COUNTY COUNCIL'S RESPONSE TO CONSULTATION ON THE FOLLOWING DEVELOPMENT PROPOSAL

Application No: 19/00439/REM

Proposal: Reserved matters to 10/01642/OUT - Dorchester Phase 7A, comprising the provision of eleven, two bed affordable dwellings with associated landscaping, car parking, infrastructure and external works.

Location: Heyford Park Camp Road Upper Heyford Bicester OX25 5HD

DRAWING TITLE: EXTERNAL WORKS
DRAWING NO: 0521-PH7A-104

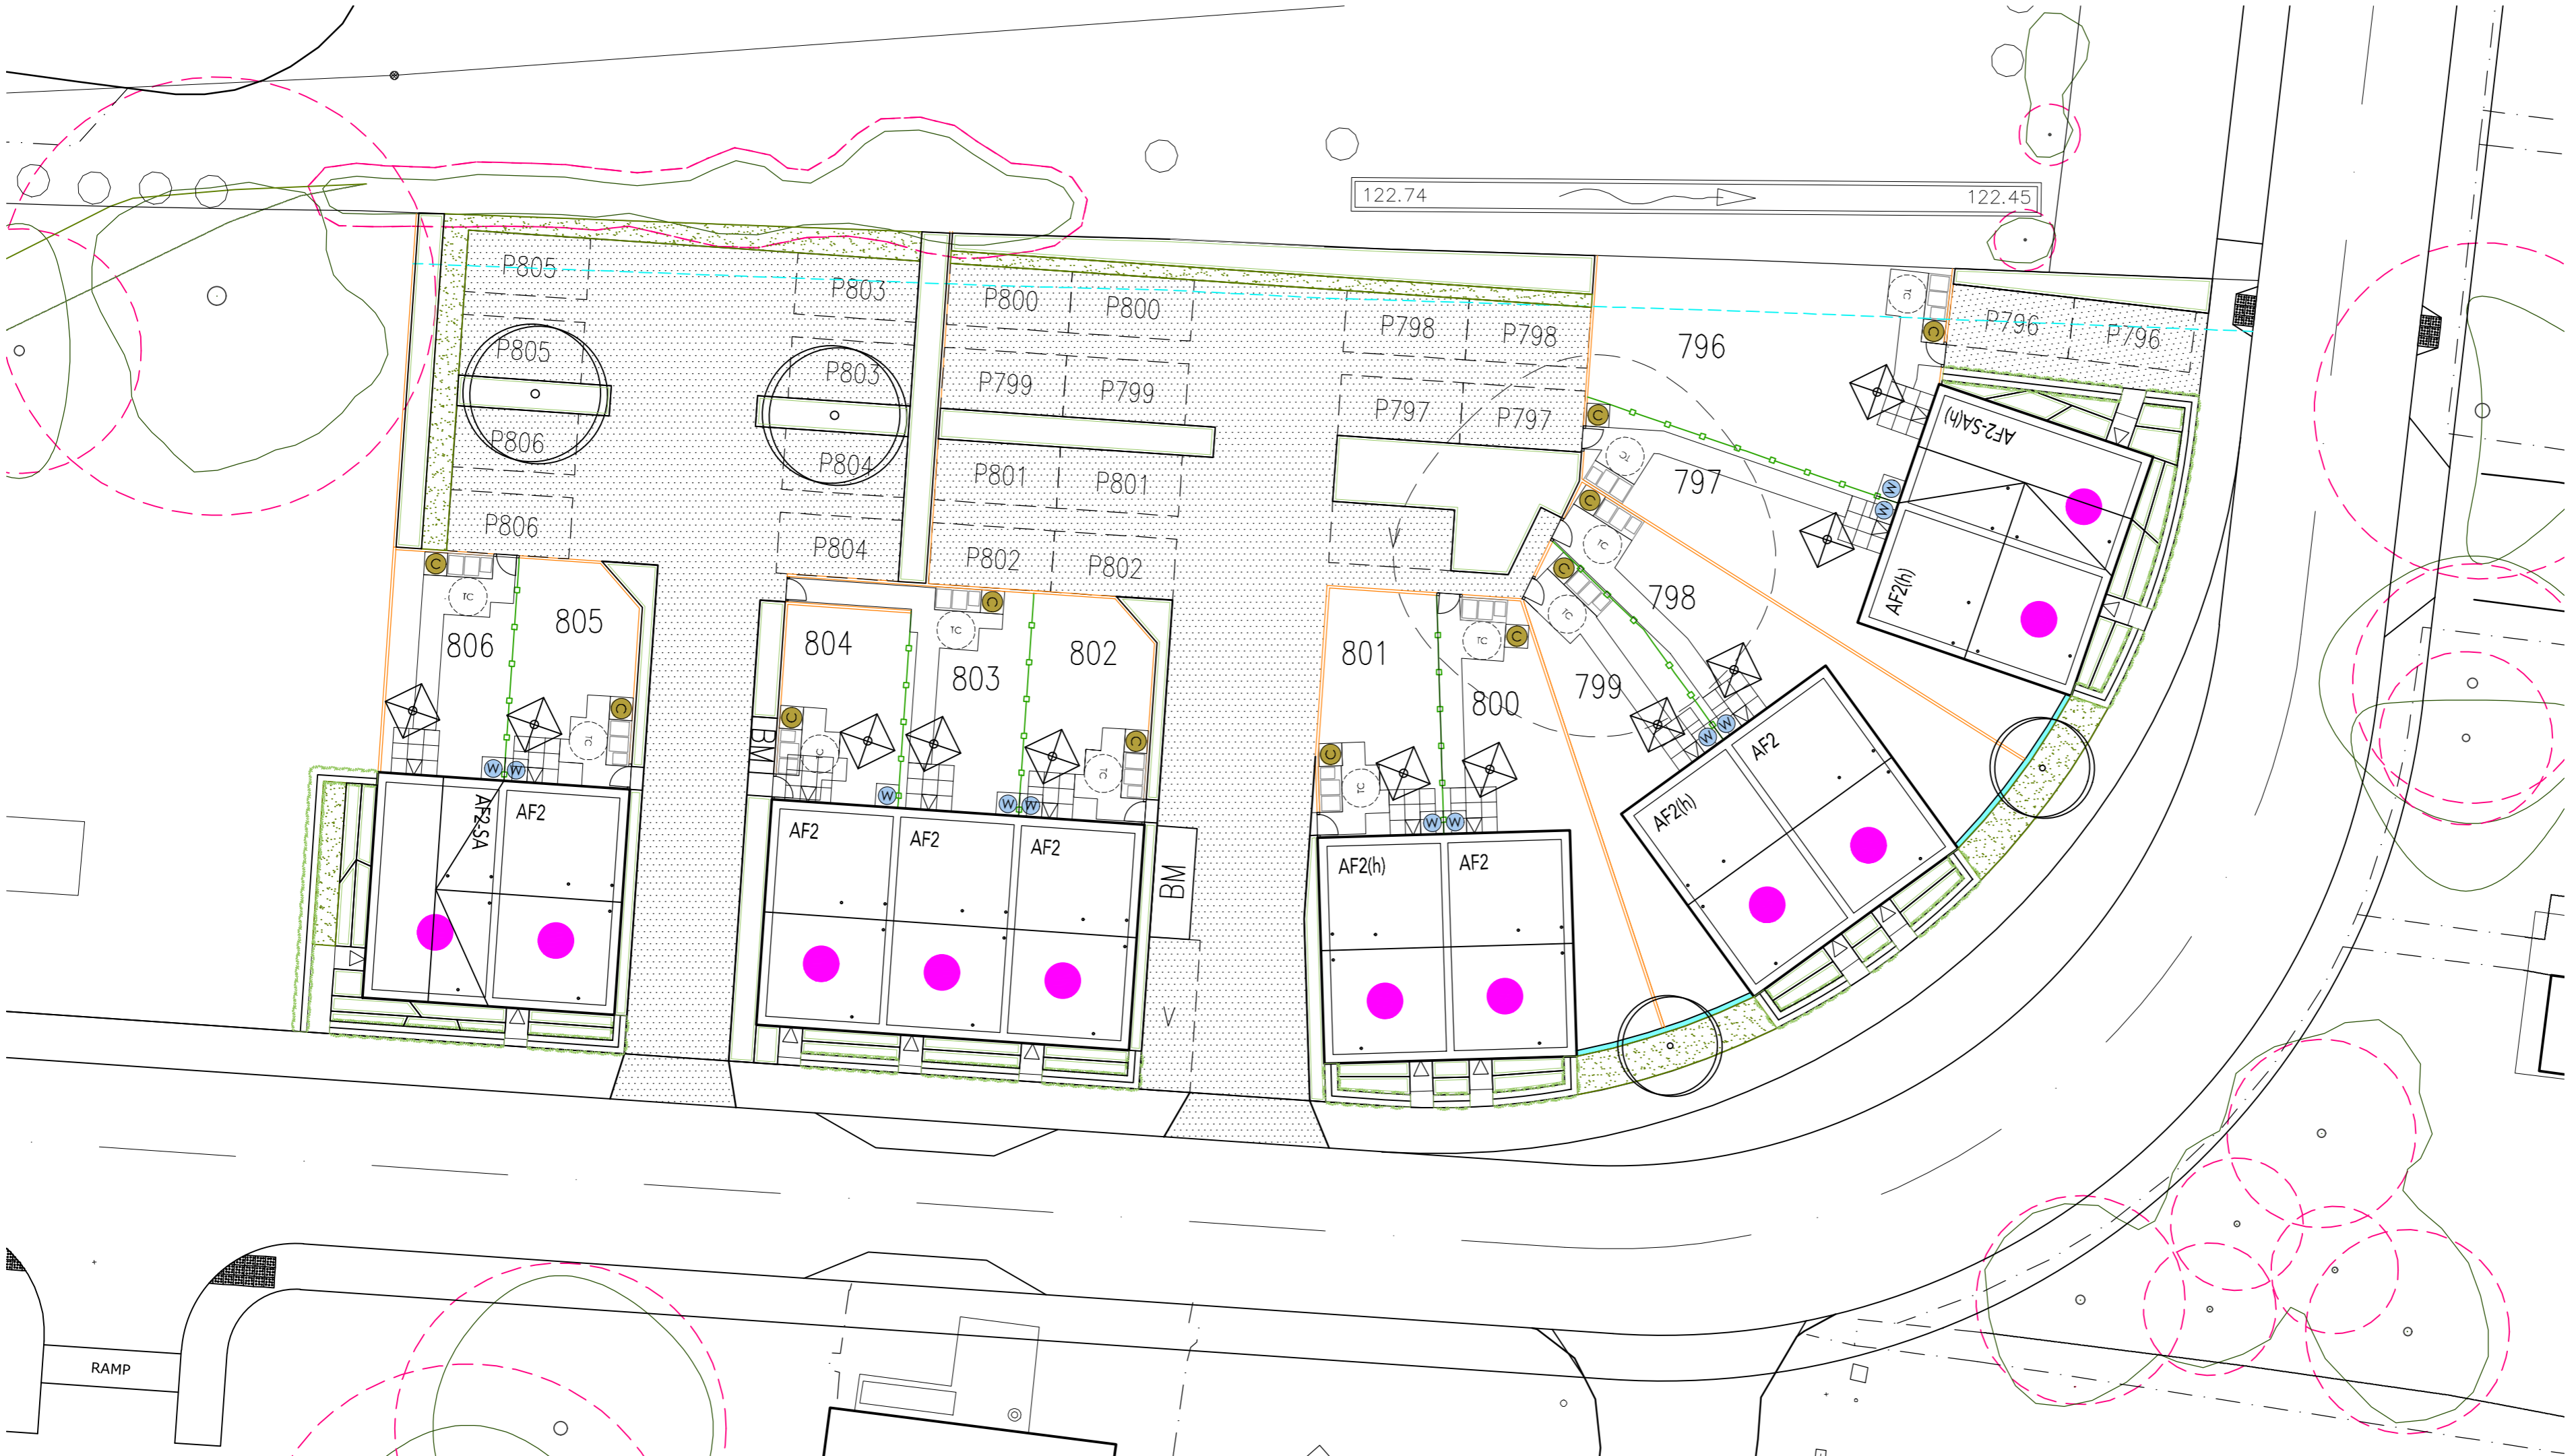
The parking access adjacent to plots 801 and 802 is of concern regarding visibility on the corner to see oncoming traffic. It would be less of a concern if this provided access to a small number of spaces but there is provision for 14 parking spaces here so the number of movements will be significant for the location. This would benefit from being rearranged, or at least a plan showing vision splays should be provided.

Parking spaces next to plot 796 are of concern since reversing manoeuvres out of these spaces are likely and visibility of oncoming traffic round the bend is poor.

Refuse collection is not obvious for plots 797-800, 803 and 806 and should be clarified. **Reason for objection.**
